Application No: AB/27/20/PL
Site Address: 6 The Old Slipway River Road Arundel BN18 9EY
Description of works: New balcony. This application may affect the setting of the Arundel Conservation Area.

Thank you for your internet representation made on 18th May 2020 which has been recorded as an objection with the comments as follows:

DRAWING
Second Floor Plan + Elevations
as Proposed

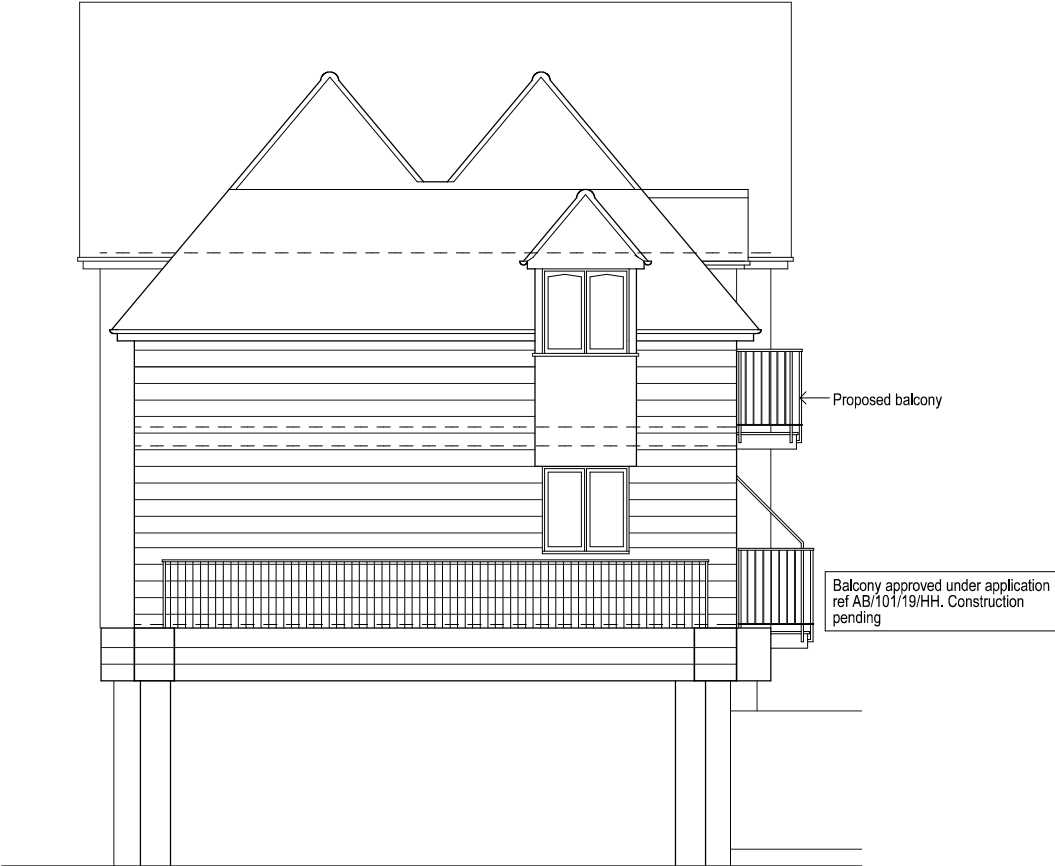
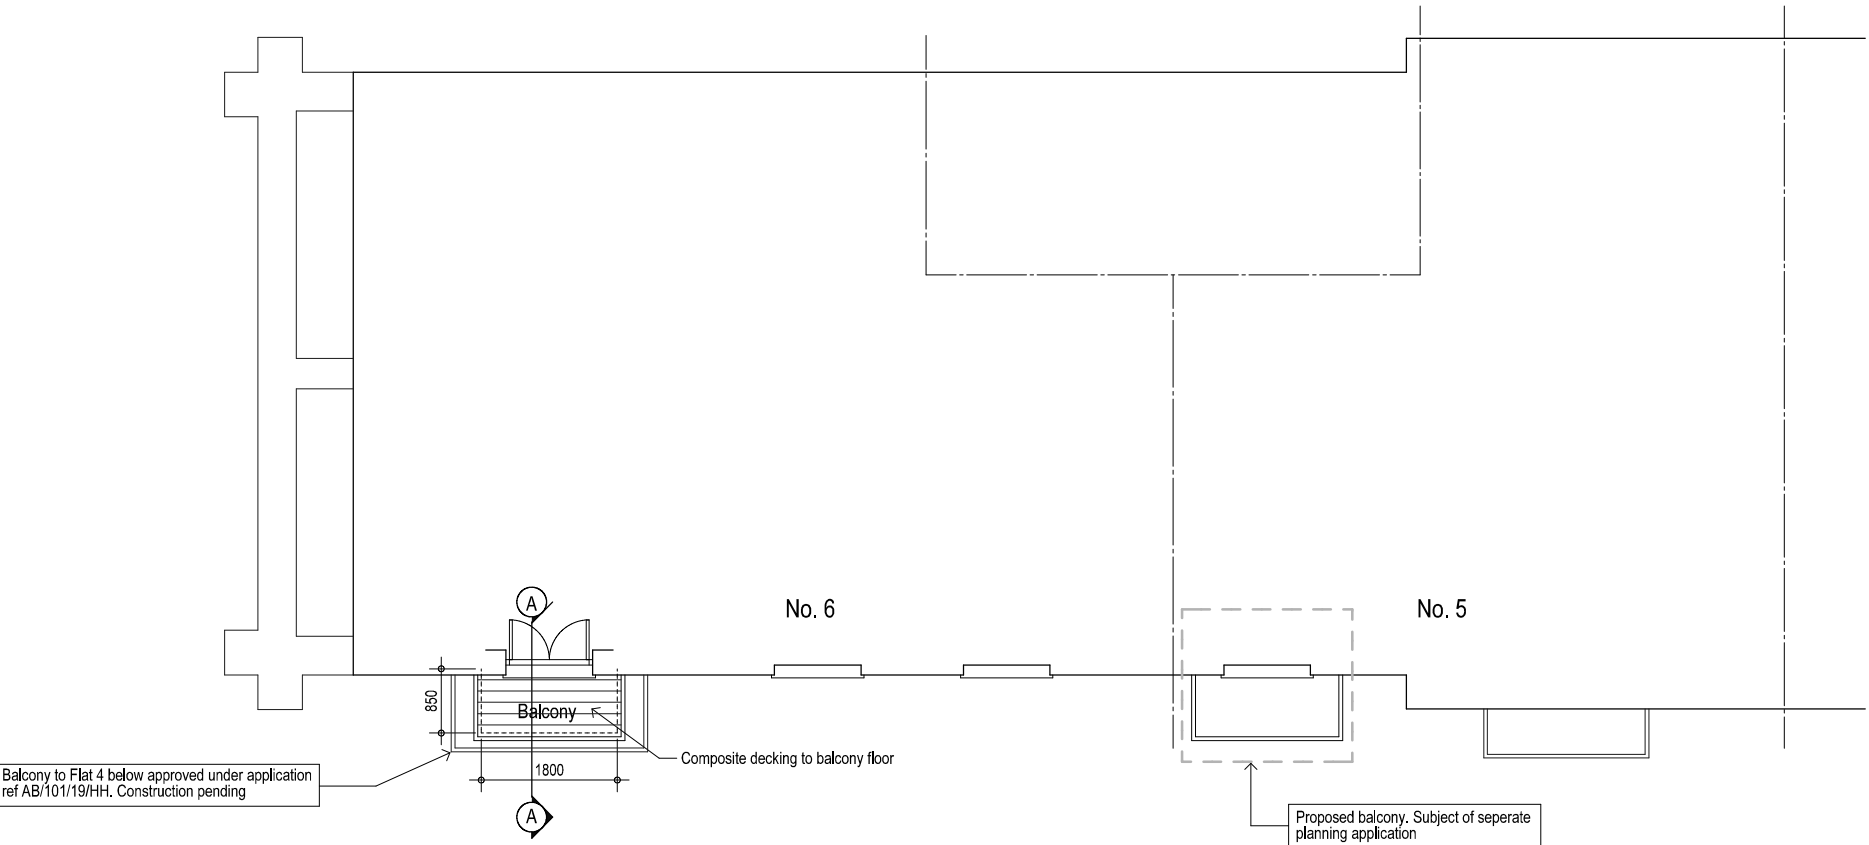
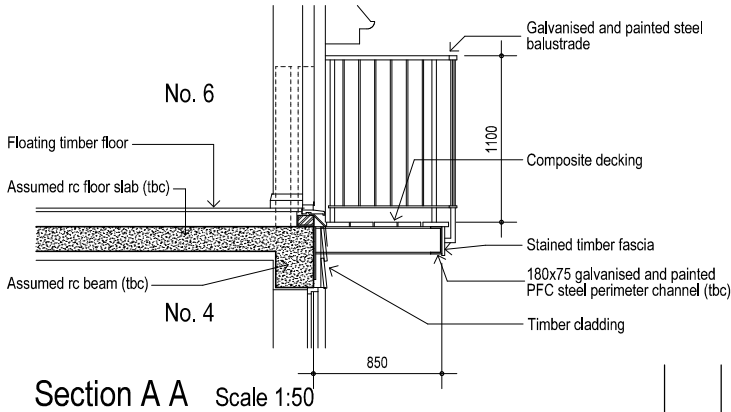
I live and own flat 2, the old slipway. This flat is the ground floor flat and the only flat with the terrace. I object as I feel that adding balconies to the second floor where there are currently no balconies would harm the character from the building. I feel that balconies at this level would be overbearing and this would affect the character of the building from the river and my terrace.

I also feel that this balcony would severely affect the privacy and my enjoyment of my private terrace. I would be overlooked clearly from this proposal. This overlooking is amplified when considering that there is now two applications from this building on the second floor. Both would overlook my terrace.
